January 26, 2023  
Merrick Project No. 65121260

**Re: Chick-Fil-A/ Extend the Drive-thru  
8110 San Pedro Dr. NE  
DRB Comments  
PR-2019-002213  
SI-2022-02430-SITE PLAN AMENDMENT**

Merrick & Company has reviewed the comments dated January 10, 2023 regarding the Chick-fil-A development. The following summarizes Merrick's responses to the comments provided by the City of Albuquerque Development Review Services.

CONSULTANT PROJECT # 65121260
 PRINTED FOR APPROVAL
 DATE 02/28/2023
 DRAWN BY KEA
 SHEET
SITE PLAN
 SHEET NUMBER
C1.0

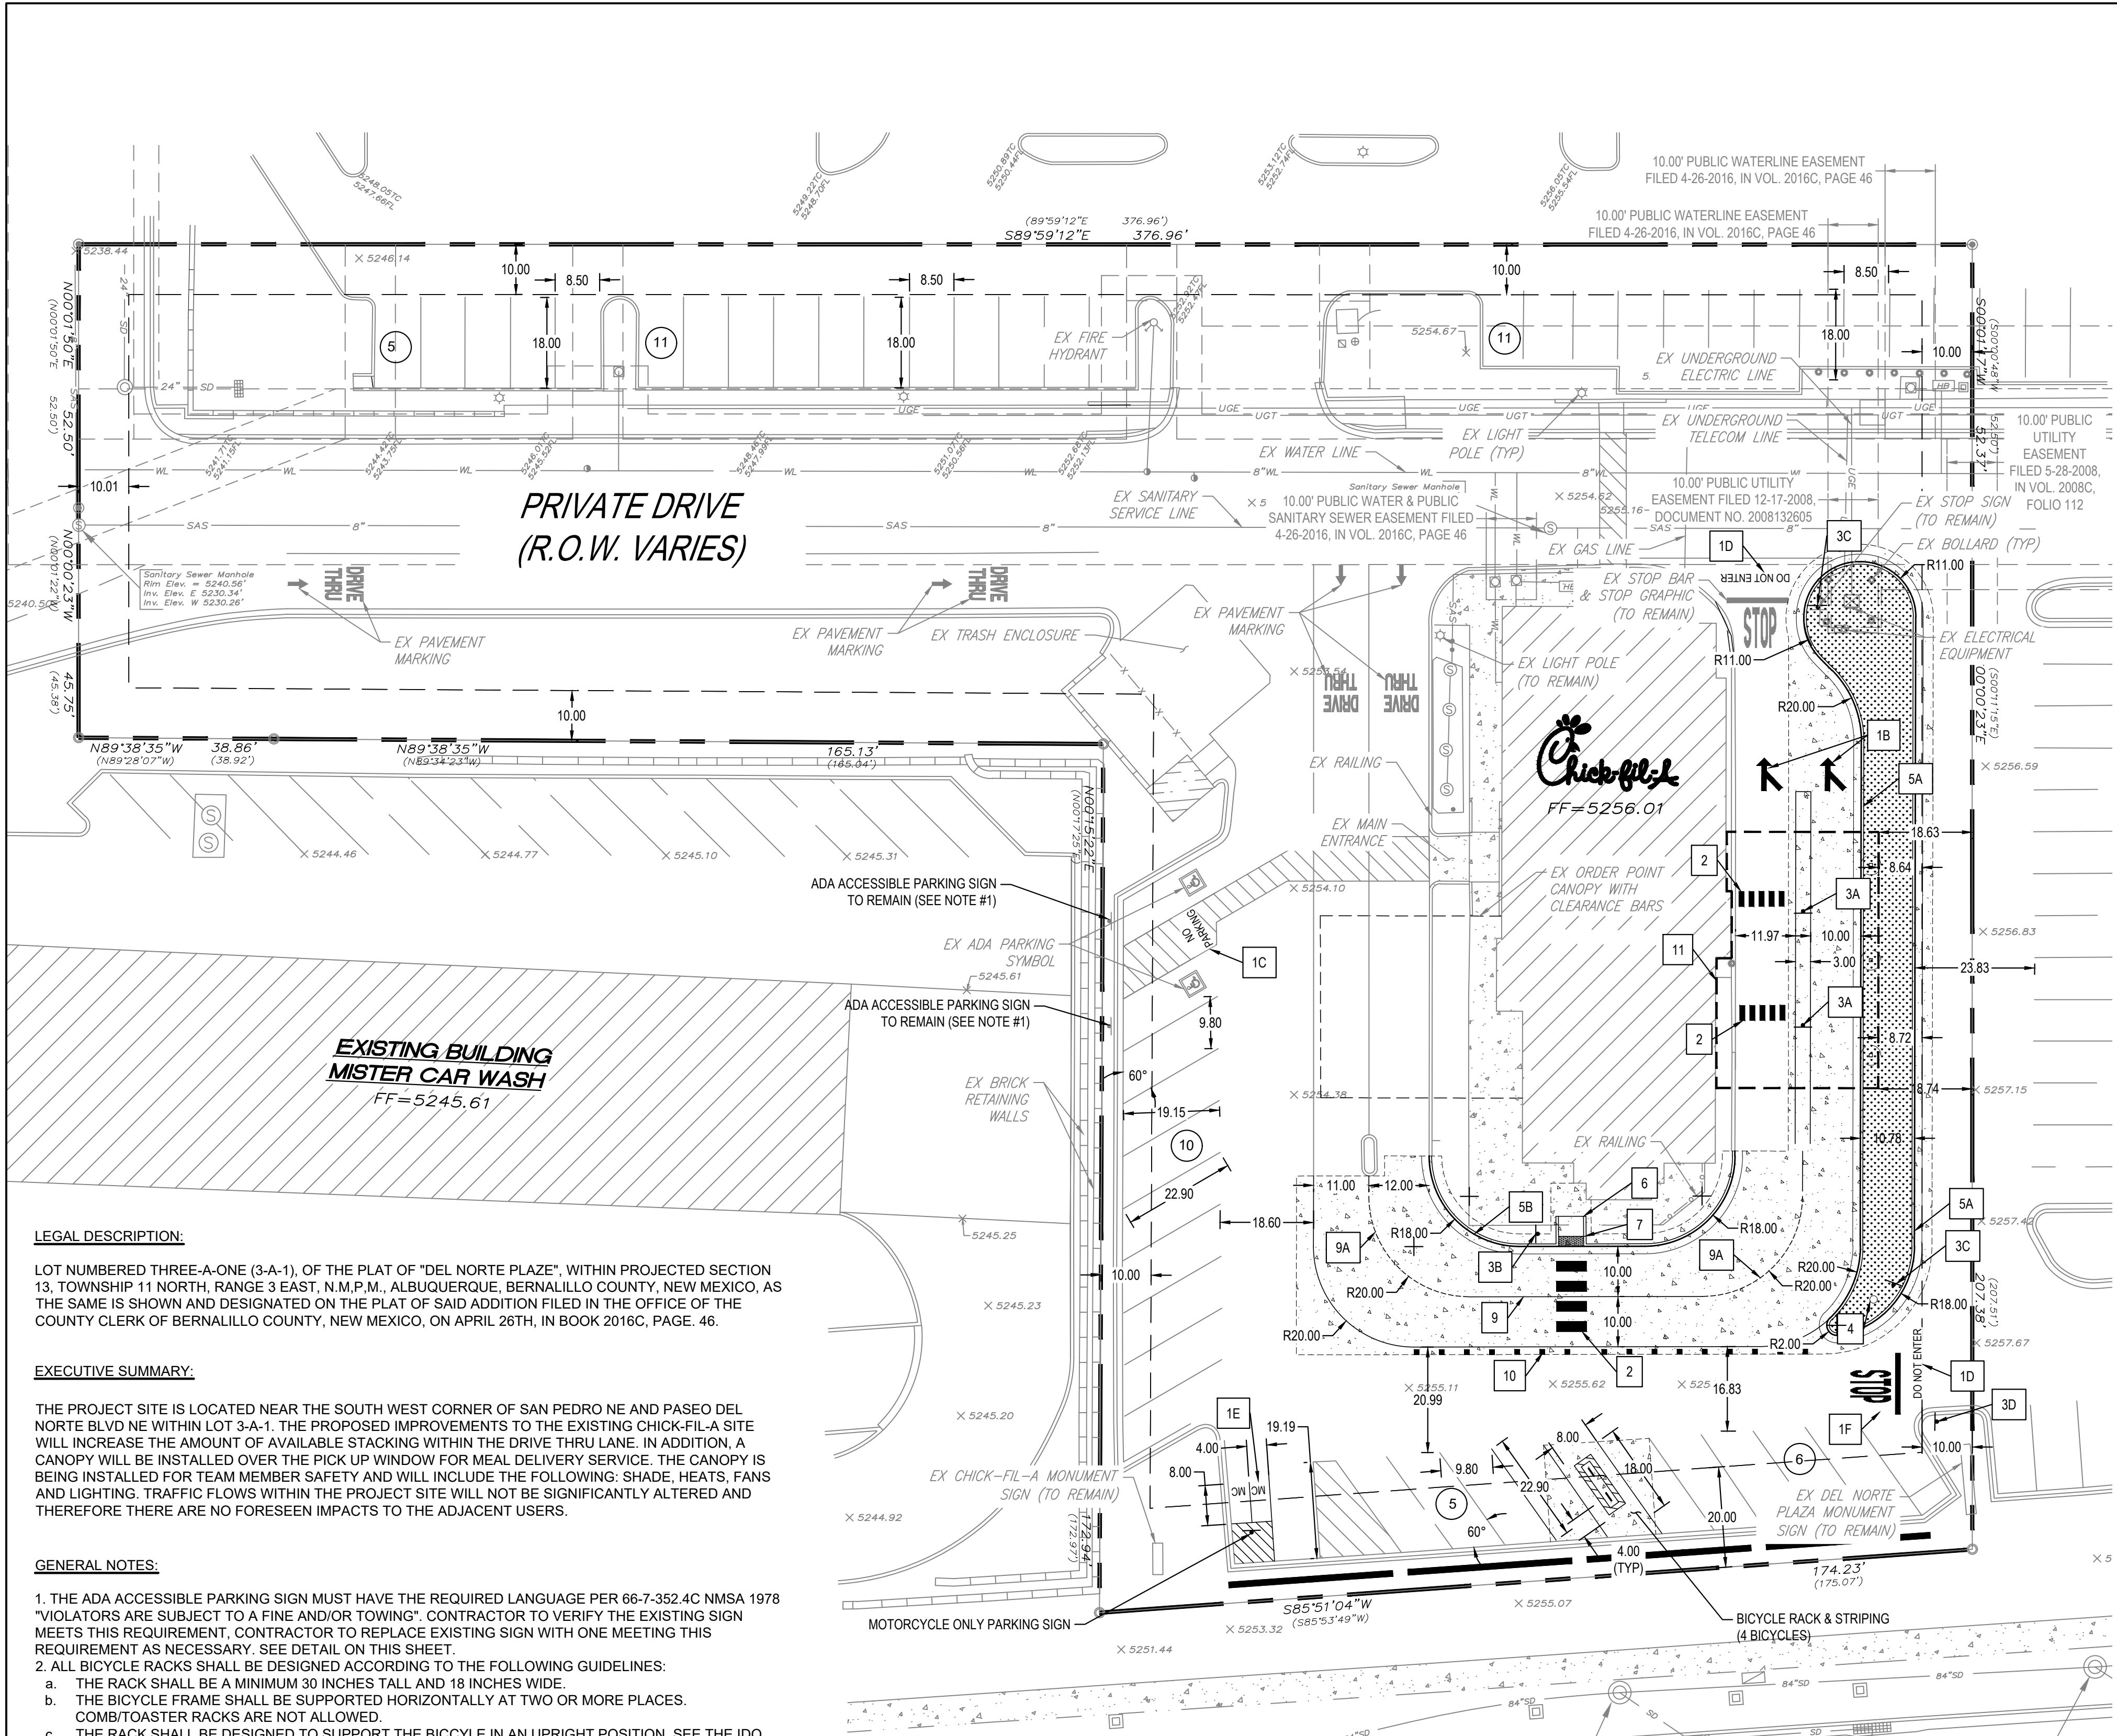
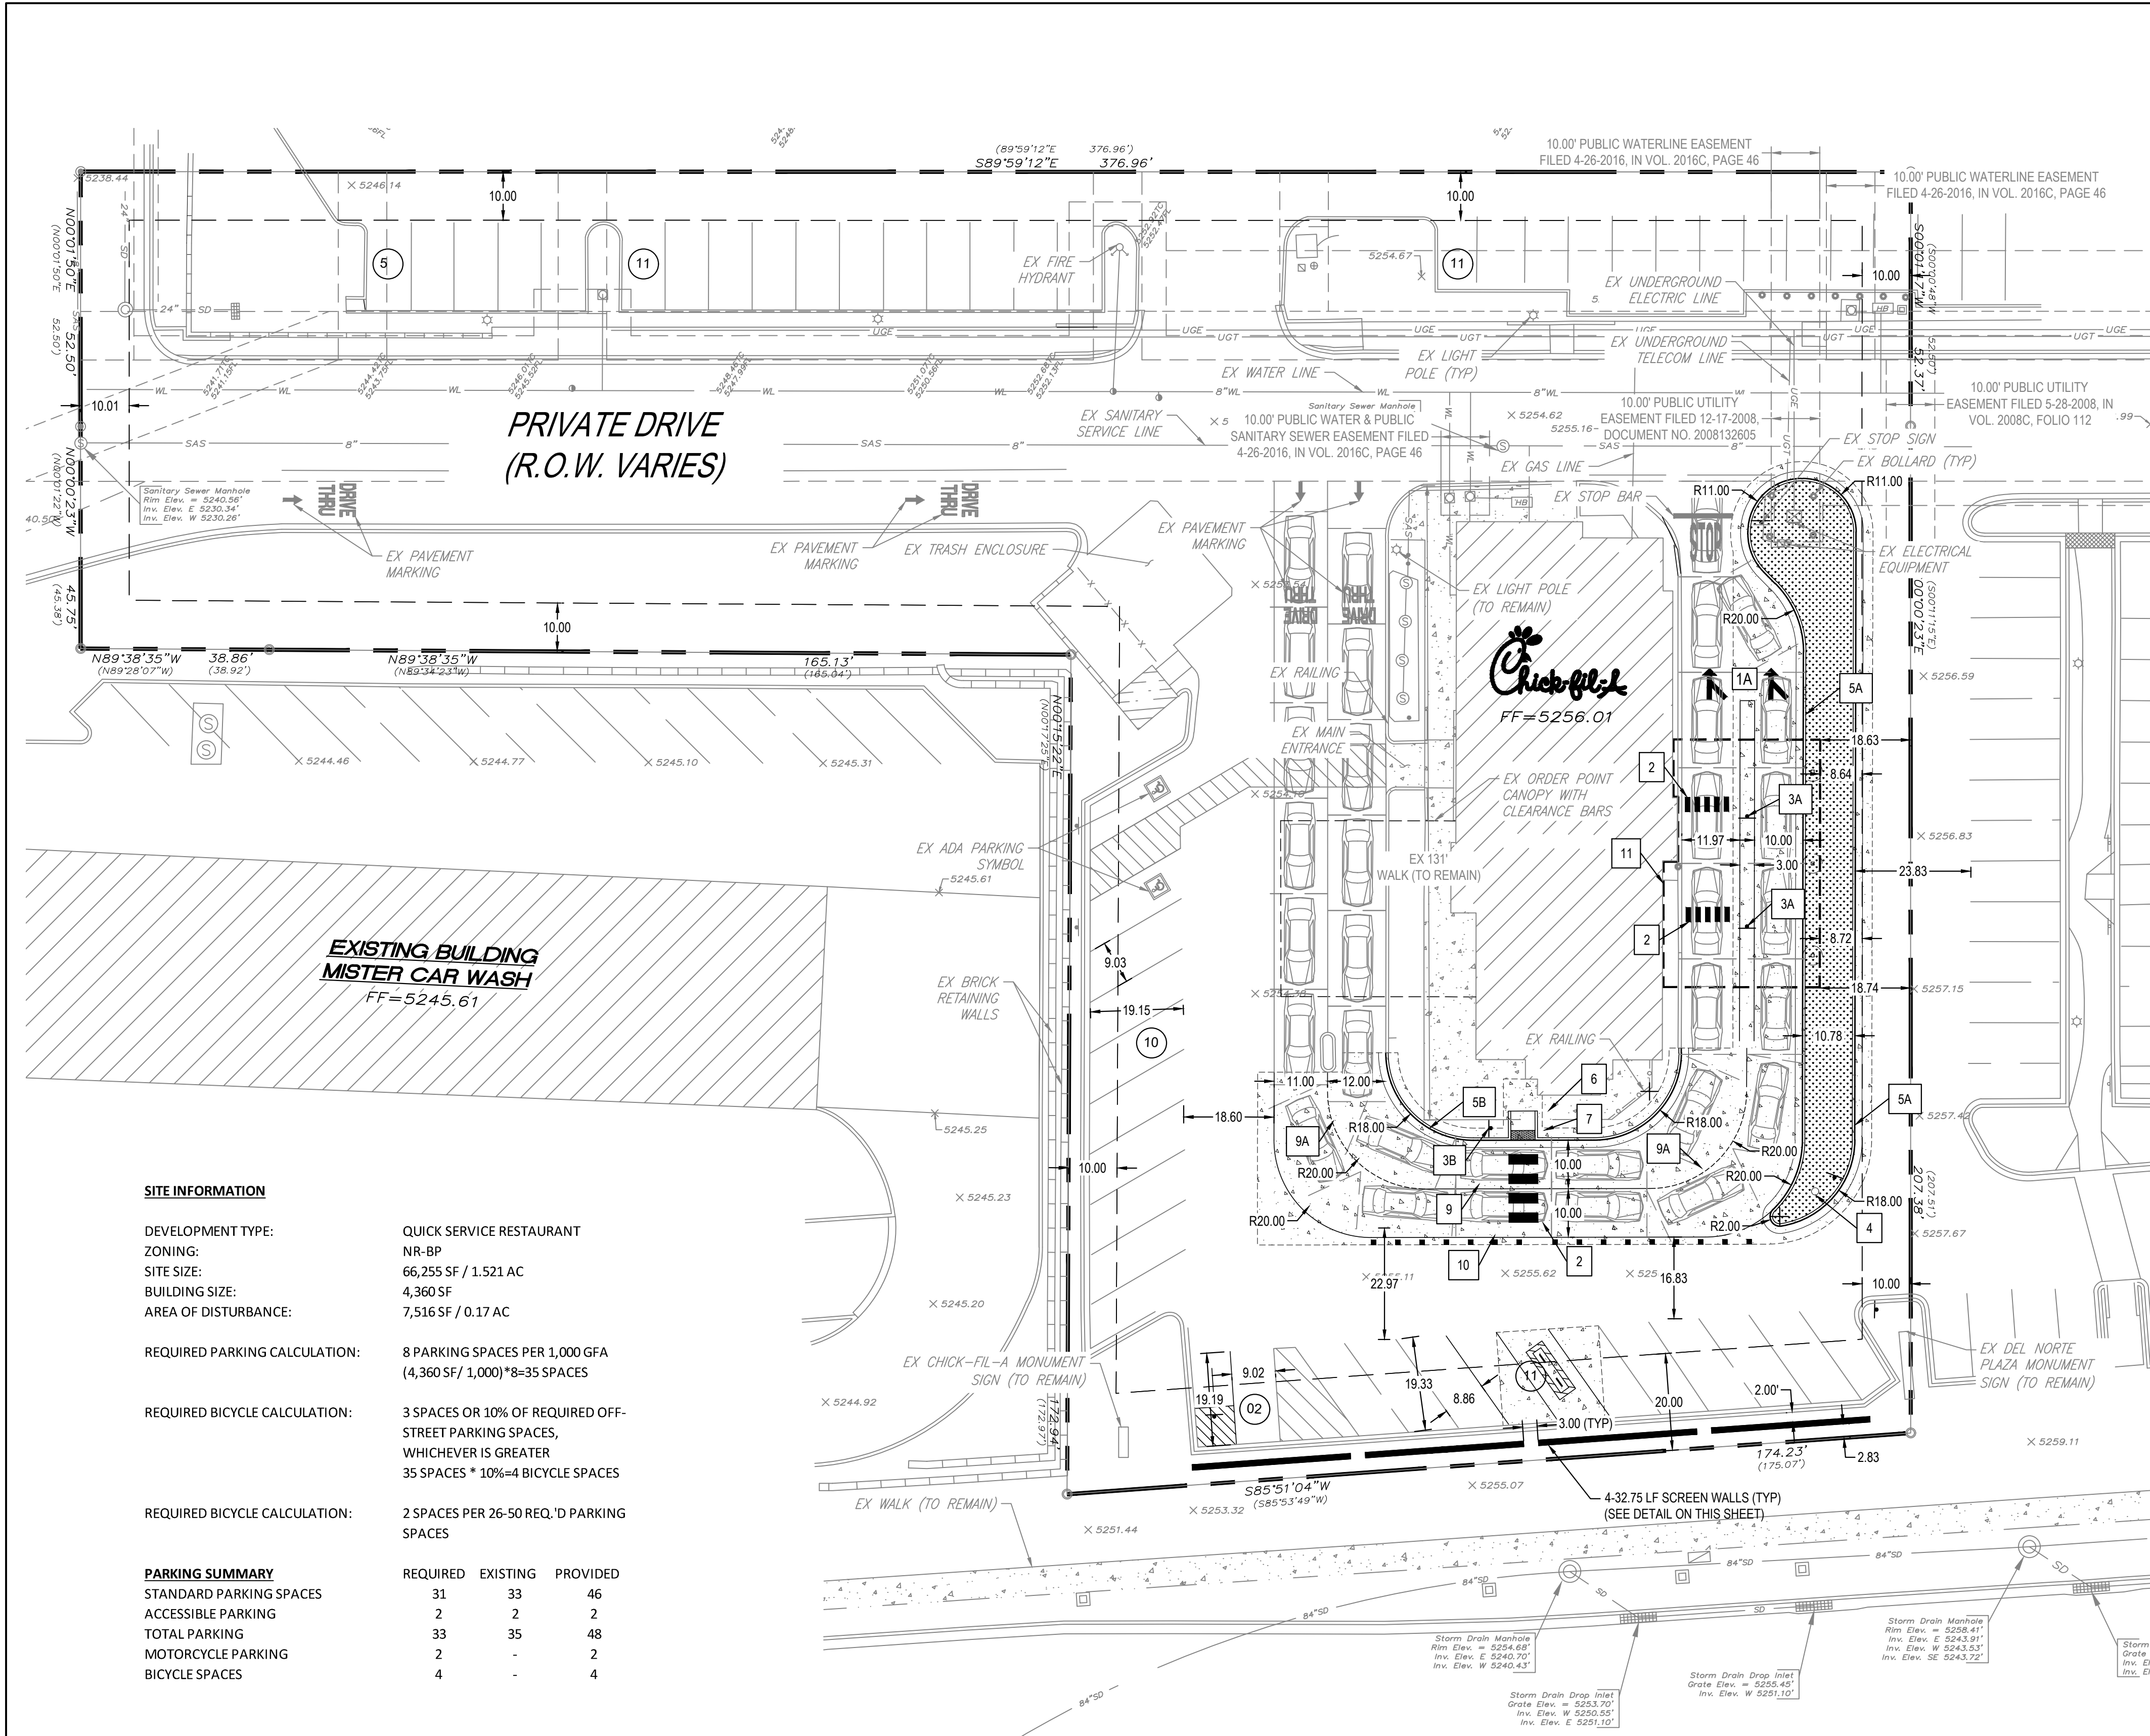
1. The signature blocks for the DRB members must be added to the Site Plan (preferably onto Sheet C1.0). The DRB signature blocks can be obtained at the following link:  
<https://documents.cabq.gov/planning/development-review-board/development-review-board-site-development-plan-signature-block.pdf>

2. The project number (PR-2019-002213) and application number (SI-2022-02430) must be added to the Site Plan.

4. The parking data shown on the previous approved Site Plan must be shown on the Site Plan Amendment as well, preferably on Sheet C1.0. The previous approved Site Plan noted that 1 motorcycle parking space and 2 bicycle spaces are required. Confirmation that they are being provided must be noted on the amended Site Plan. Staff will note that while the parking requirements of the previous approved Site Plan appear to be met, a large number of parking spaces are being removed from the site east of the existing building (Chick fil A restaurant).

19. Provide shared parking agreement for leased parking spaces north of store. Confirm there sufficient remaining spaces for the businesses in that location.

20. Show capacity of vehicles in stacking lanes on site plan.

**Response:** The signature blocks for the DRB members as provided in the above link has been added to the Site Plan (Sheet C1.0)

**Response:** The project number and application number have been added to the Site Plan.

Response: A Site Information table containing a Parking Summary has been added to Sheet C1.0 describing how the development is meeting the parking requirements. A total of thirteen (13) spaces are being removed along the east side of the existing building (Chick-fil-A). The Property Boundary of the Site was re-platted and approved 04/26/2016 to include the twenty-seven (27) parking stalls within the parking lot to the north, a copy of this plat has been included for reference, and the parking summary table reflects these numbers.

Response: A Site Information table containing a Parking Summary has been added to Sheet C1.0 describing how the development is meeting the parking requirements. A total of thirteen (13) spaces are being removed along the east side of the existing building (Chick-fil-A). The Property Boundary of the Site was re-platted and approved 04/26/2016 to include the twenty-seven (27) parking stalls within the parking lot to the north, a copy of this plat has been included for reference, and the parking summary table reflects these numbers.

Response: Drive-thru vehicles have been added to the site plan for stacking reference.
